RE: PD-24-00001 Roslyn Ridge West

**SUBJECT: WDFW COMMENTS ON PD-24-00001 ROSLYN RIDGE WEST**

ROSLYN RIDGE WEST PLANNED UNIT DEVELOPMENT
CRITICAL AREAS REPORT REVIEW
ATTACHMENT A 1&2

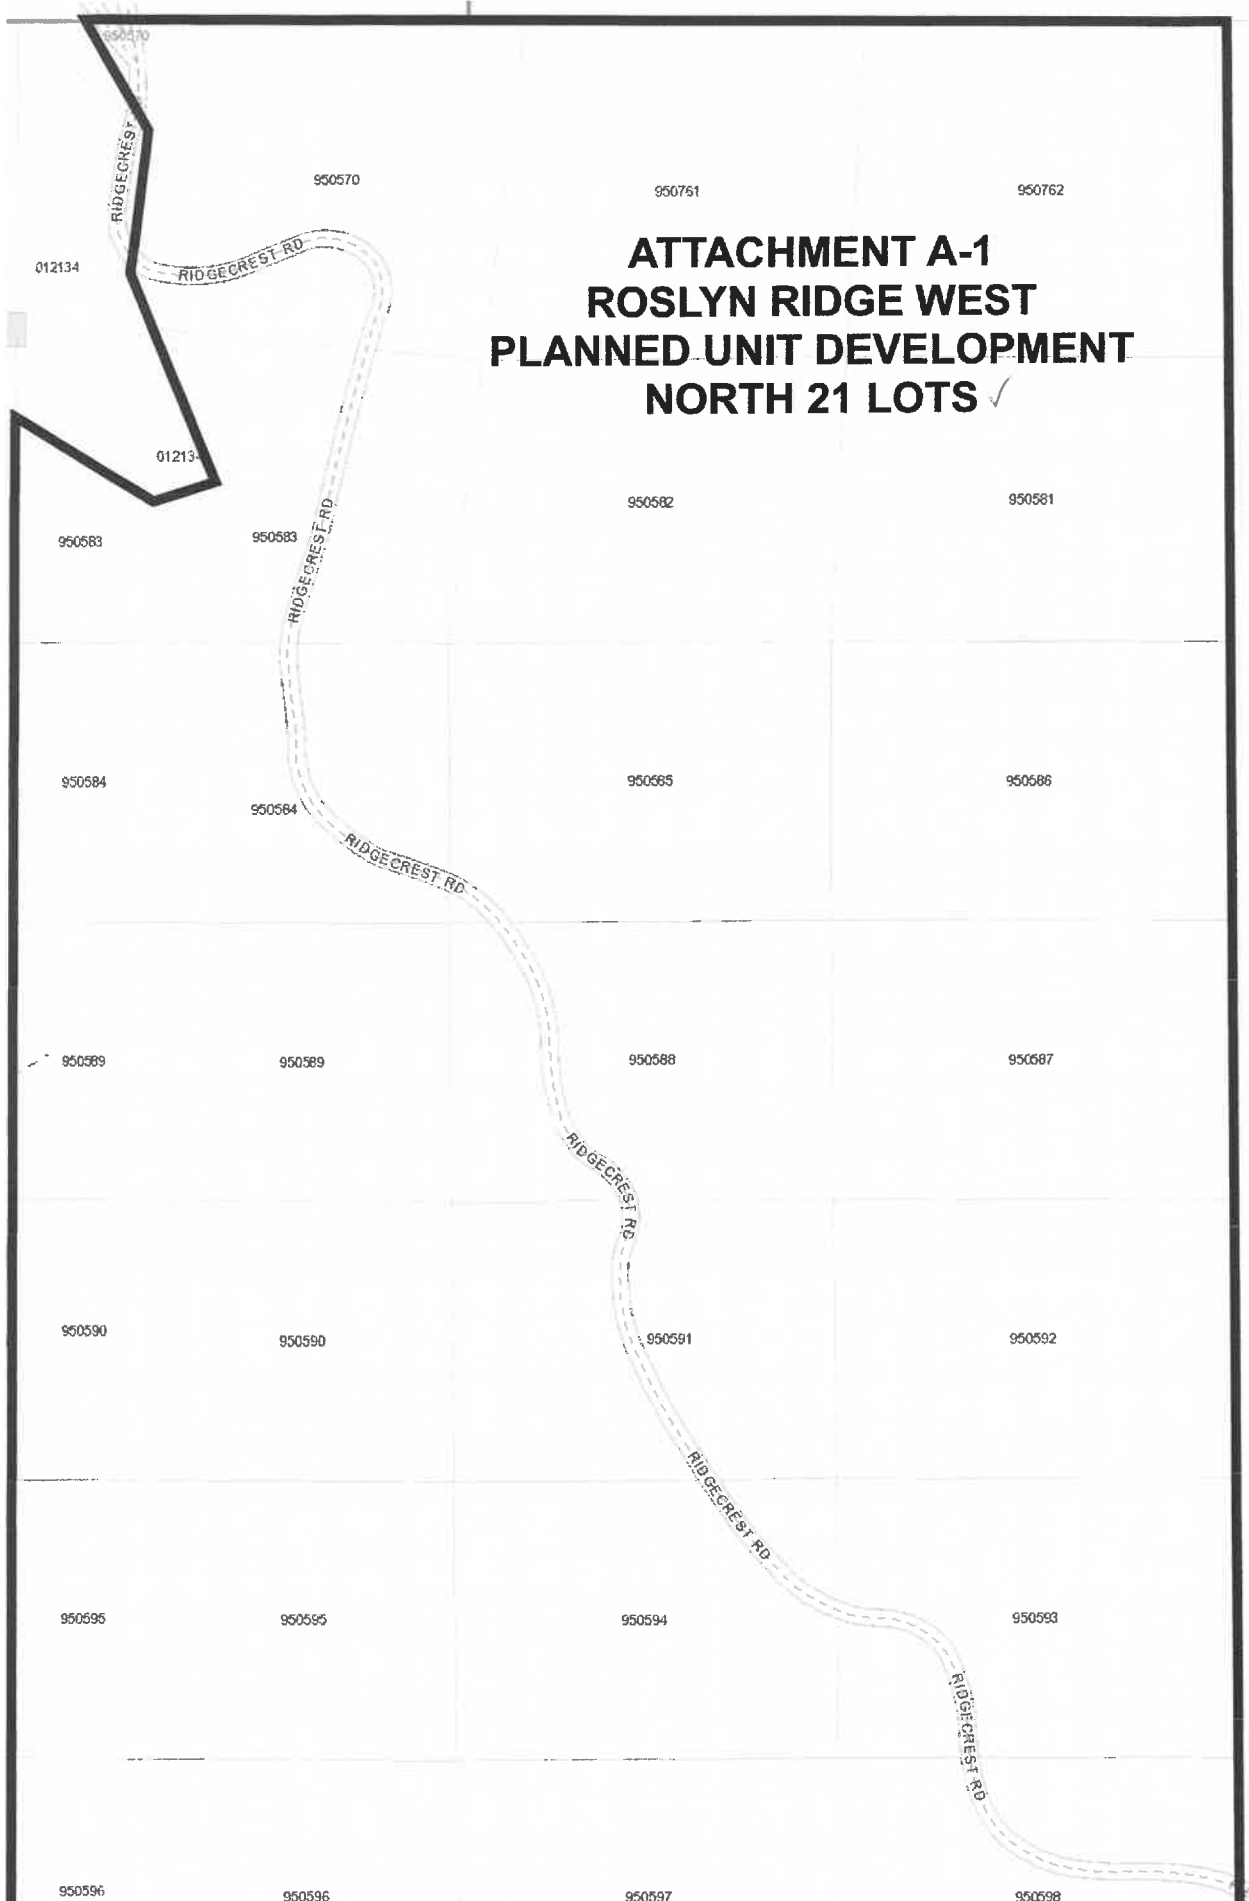
WDFW recommends that all streams and their riparian management zones or buffers be identified on the plat maps; KCC 17A.04.030 identifies a 50' buffer on Ns streams. We also request that prior to any road building or grading near the streams, you contact WDFW to determine if a Hydraulic Project Approval (HPA) is required.

WDFW is generally supportive of the Northern (21 parcels) and North-Central (171934) parcels being designated and signed as unbuildable critical areas to mitigate for the loss of habitat in the South (20202) and South-Central (12065) parcels. If the Recreational Open Space areas are to be designated as mitigation for the impacts to Priority Habitats and Species associated with the high density Planned Unit Development, motorized recreational uses should be better understood. WDFW recommends formal recognition of these properties as Native Growth Protection Areas (KCC 17A.01.090.2) such that the protection measures are formally recorded on the plats and titles and can be enforced as a permanent mitigation measure.
